Subject: RE: AW/319/20/DOC- The Former Ship Inn Aldwick Street

Block Plan
scale 1:500 @ A1

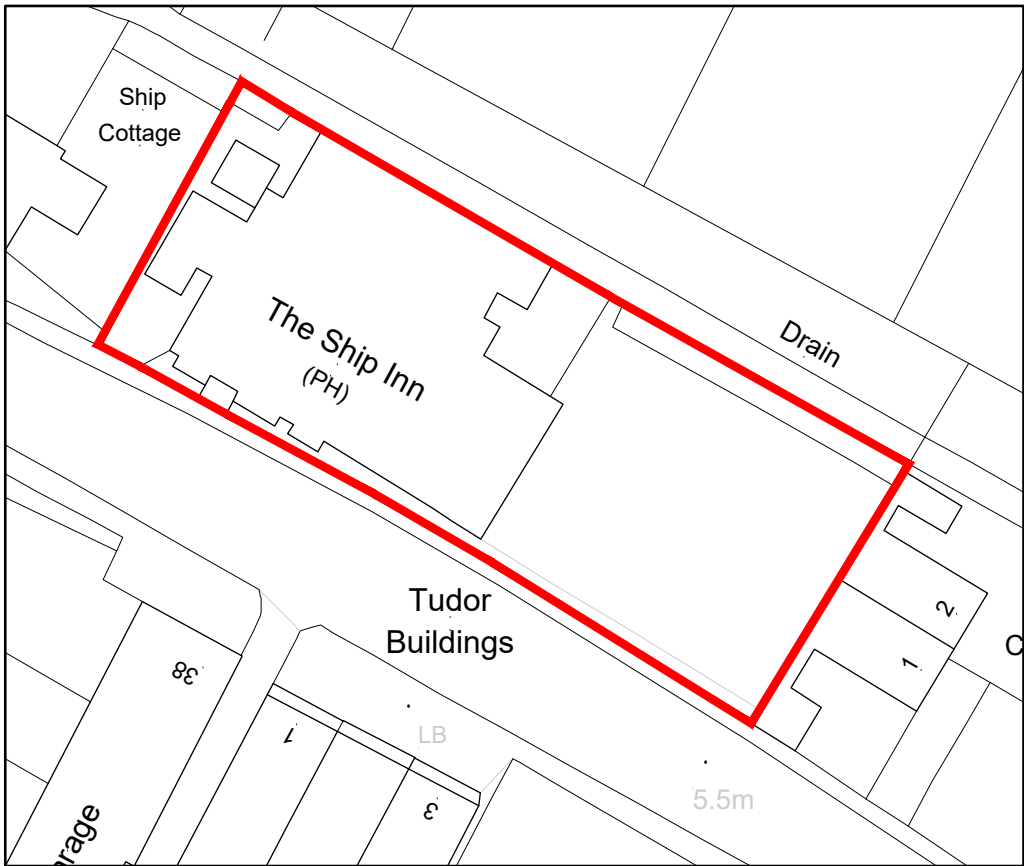
In regard to the fencing to the drainage ditch at the rear of the site, you have the plan which indicates the position and arrangement of the fencing at the site. This is unchanged. You also have details of the appearance, type and form of fencing with the application. Furthermore, there is my clarification email in regard to the arrangement of the fence, having a single removable post nearest to the lock area of the gate.

As discussed the proposals set out in an email and discussed on site should be okay. Could you please provide an updated plan with notes reflecting these proposals.

- As a minimum I would suggest there needs to be a headwall constructed around the piped outlet to the ditch, this should be in accordance with WSCC/ ADC standard details.
- There is some vegetation and debris within the watercourse. This requires clearance. We strongly recommend this is completed prior to the new fenceline being constructed.
- The furthest downstream buttress appears to have separated to some extent from the ditch retaining wall. This should be investigated as a priority and any necessary remedial works completed to ensure the stability of the wall.
- We would like to complete an inspection of the watercourse and headwall prior to the fence being constructed.

It is believed therefore that there is sufficient information for you to discharge the obligations of the discharge of condition application, relating to this topic. There is no requirement for any drawing modifications in this regard.
